Concept State Significant Development Application – SSD 18_9579
Sydney Metro City & Southwest – Crows Nest Over Station Development

I strongly object to the above referenced application for the reasons outlined below:

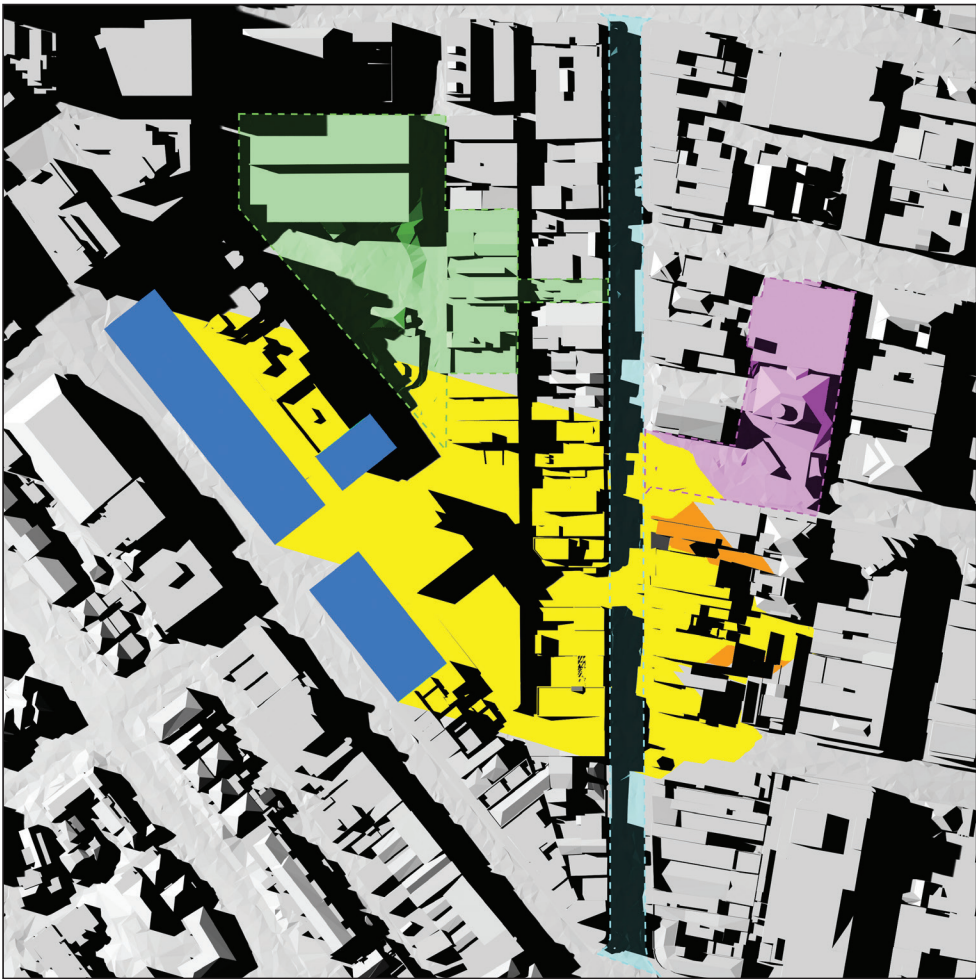
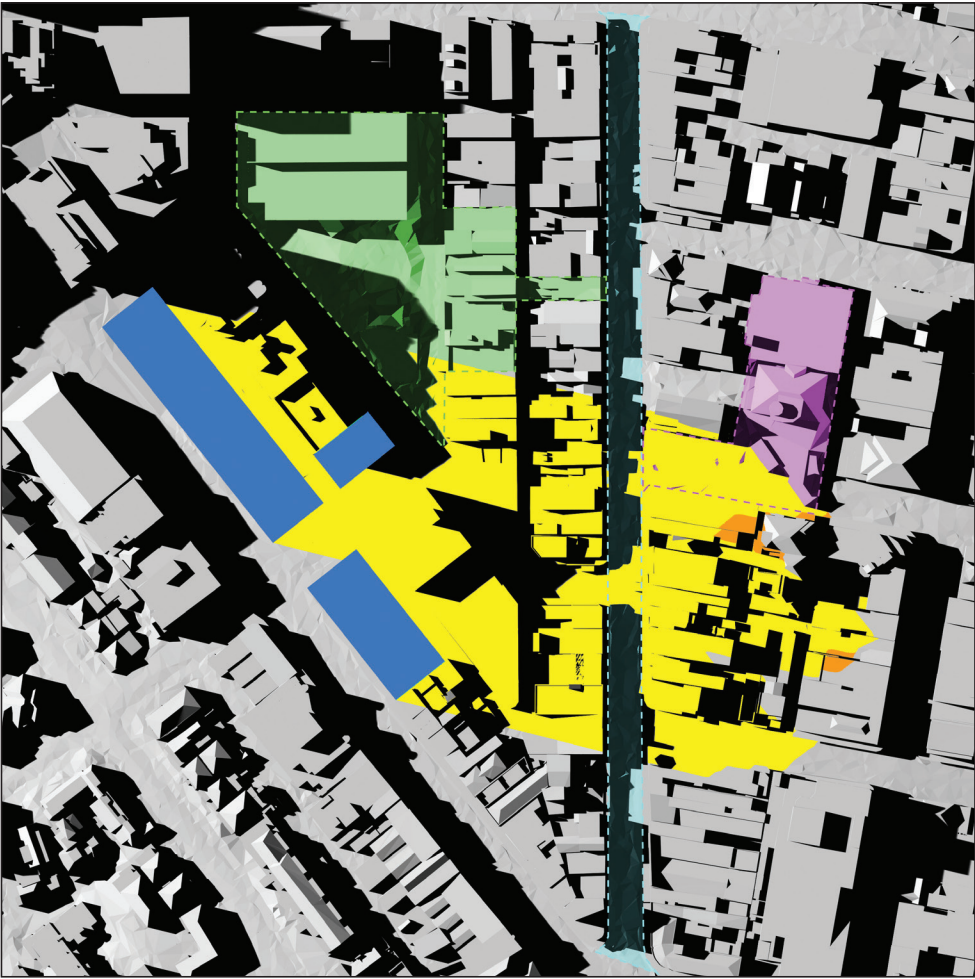
15. I object to the overshadowing of Nicholson Street, Hume Street Park, Willoughby Road and Ernest Place in particular year-round, not just between 9:00 am and 3:00 pm.
